**SECTION 75W APPLICATION TO MAJOR PROJECT APPLICATION NO. 10\_0057 FOR  
RESIDENTIAL DEVELOPMENT AT 132-138 KILLEATON STREET, ST IVES (LOT 2, DP 748682) –  
REDUCTION OF BASEMENT CAR PARKING**

Pursuant to Section 75W(1)(a) of the Environmental Planning and Assessment Act, 1979, a "Modification of Approval" is sought to modify the number of visitor car parking spaces. Consent is therefore sought to vary Conditions B12(a) and B1A(f) of MP10\_0057.

CARPARK LEVEL 2 STAGE-2
SCALE 1:200

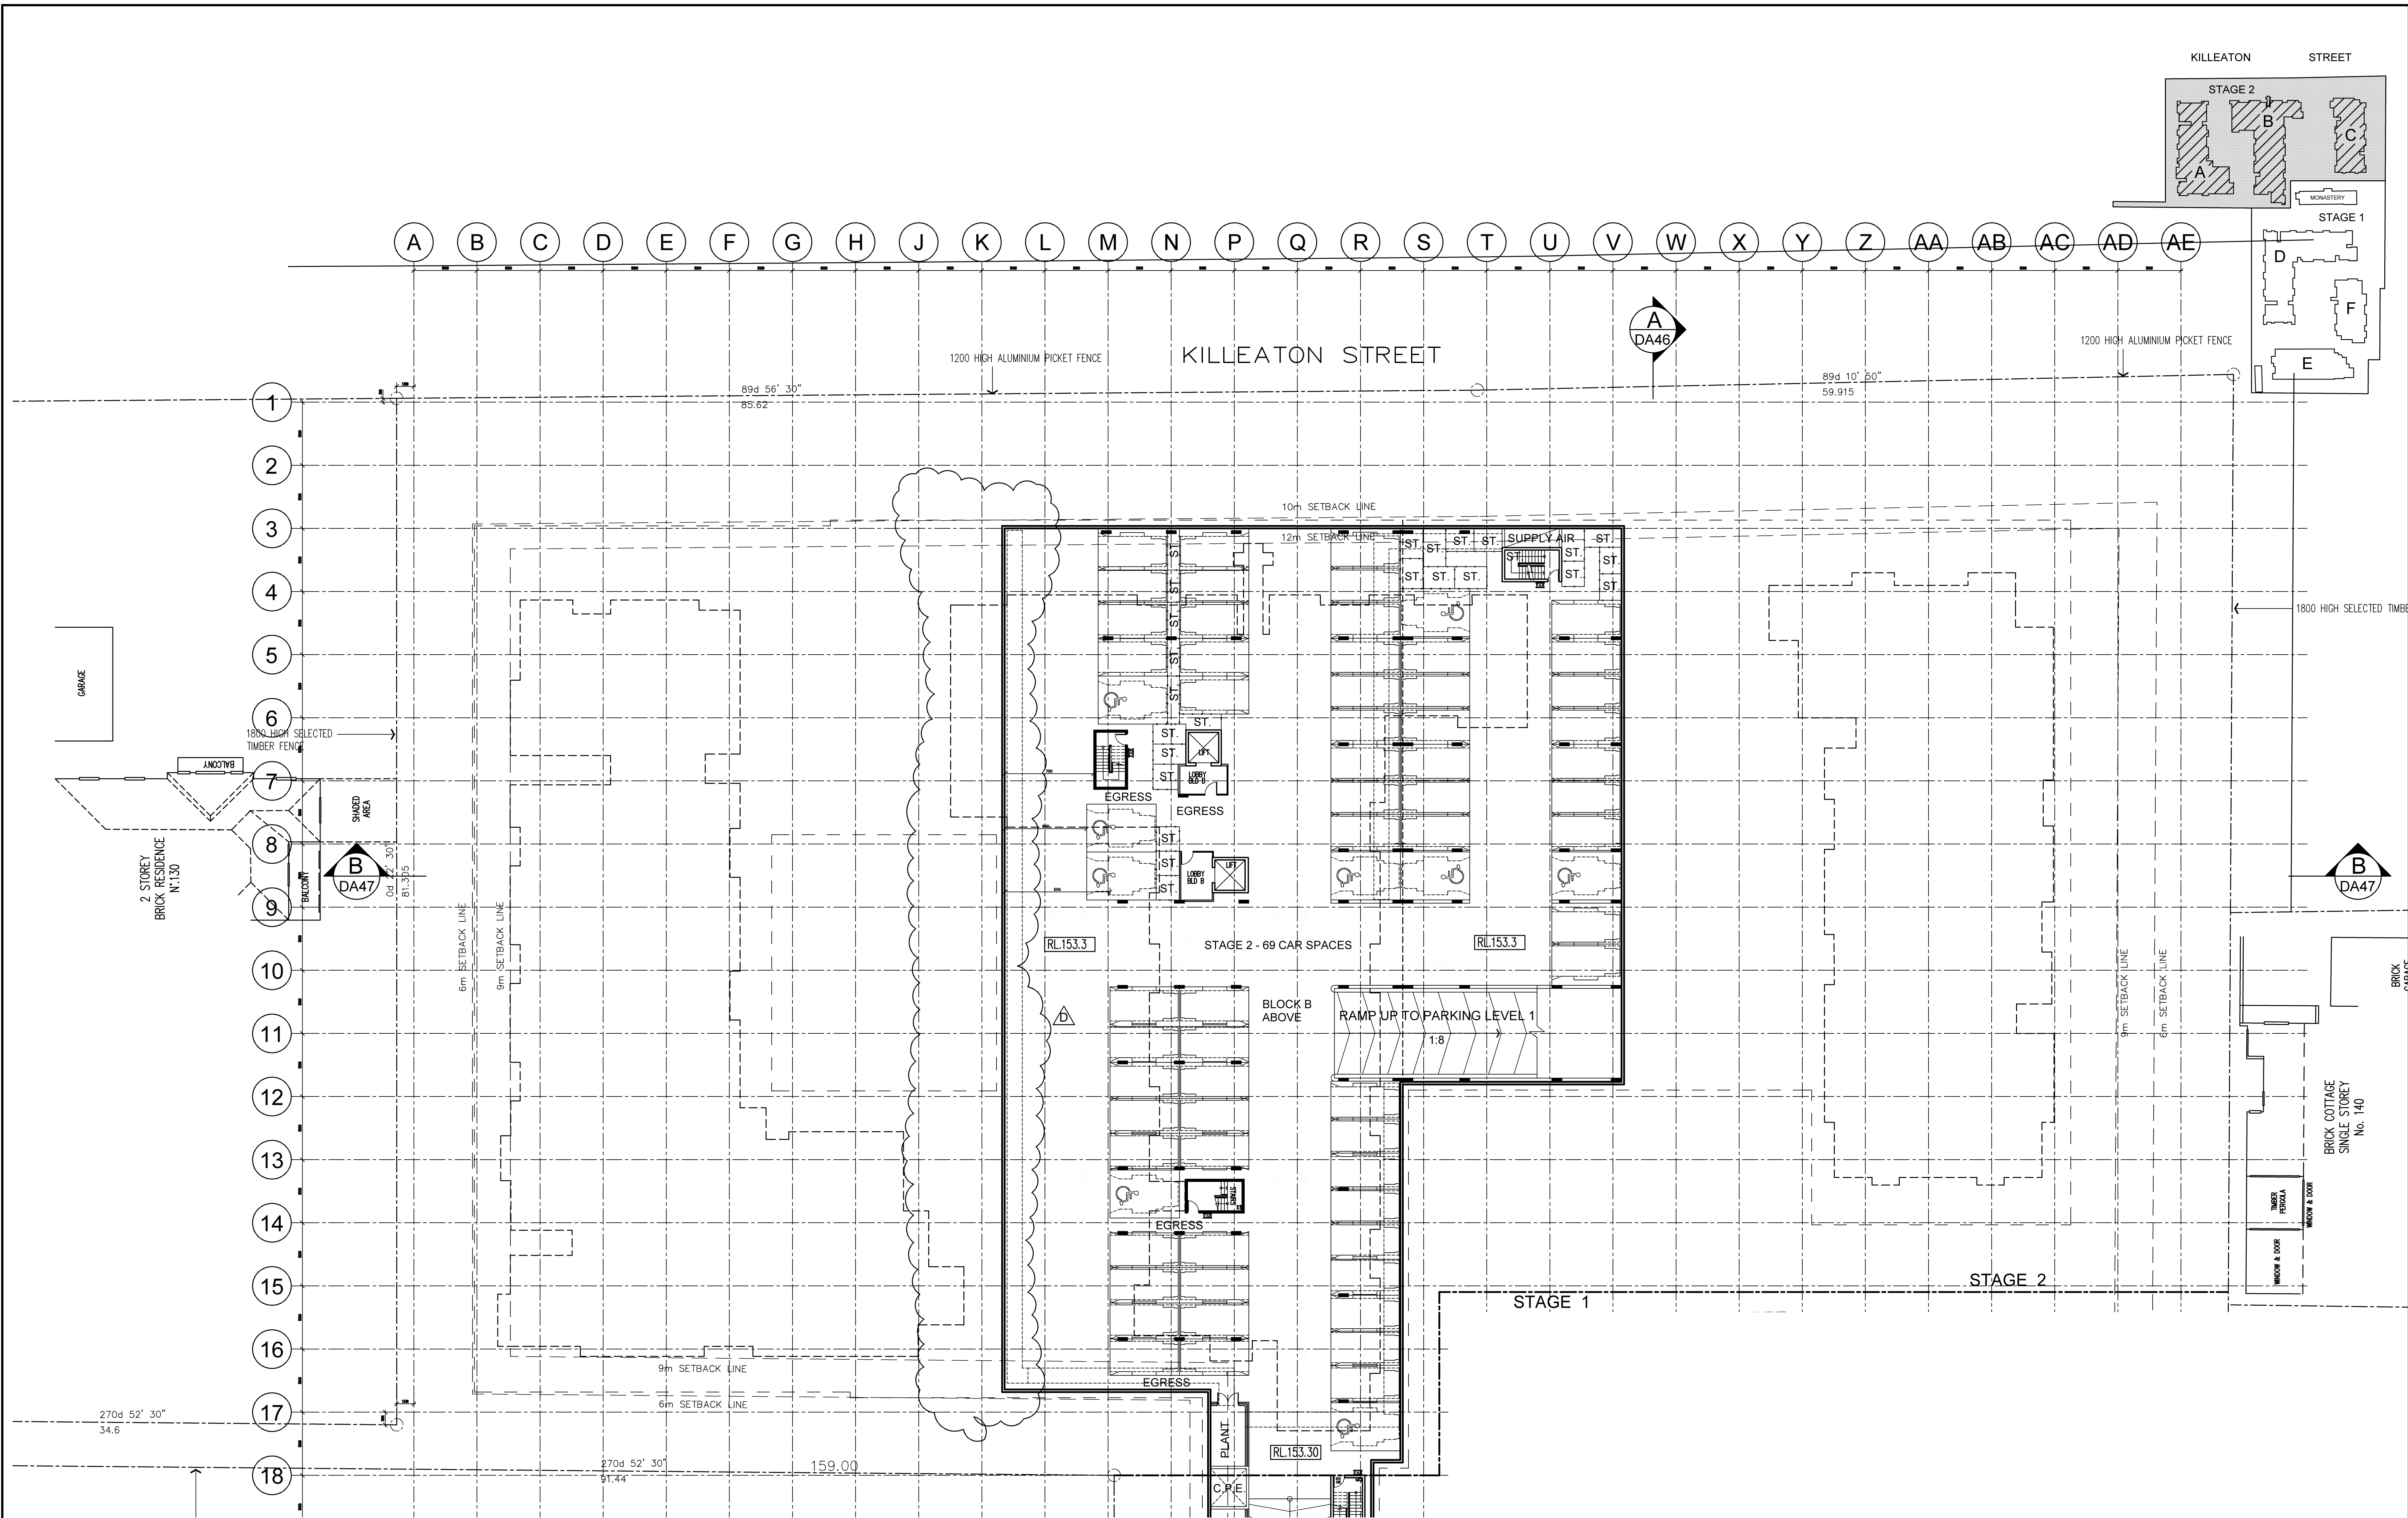
1. Modify the number of visitor car parking spaces.

Given that the basement is currently under construction, there is only the ability to reduce the number of visitor parking spaces. Halcrow Traffic consultants have reviewed the visitor car parking and a report is contained in **Annexure 2**.

The reduction in the overall footprint of the basement car park will create more deep soil open space for future residents. The deep soil area has been increased from 40.1% to 40.4%.

- a. ~~Parking must be provided in accordance with the requirements for visitor and residential parking in the Kuring-gai Development Control Plan (Town Centres) 2010. **A total of 369 car parking spaces are to be provided within the basement, including a minimum of 48 visitor parking spaces.** Visitor parking shall include a minimum of 2 spaces designated for persons with a disability. The design and construction of the parking area and parking spaces must be in accordance with AS2890.1 and AS2890.6.~~
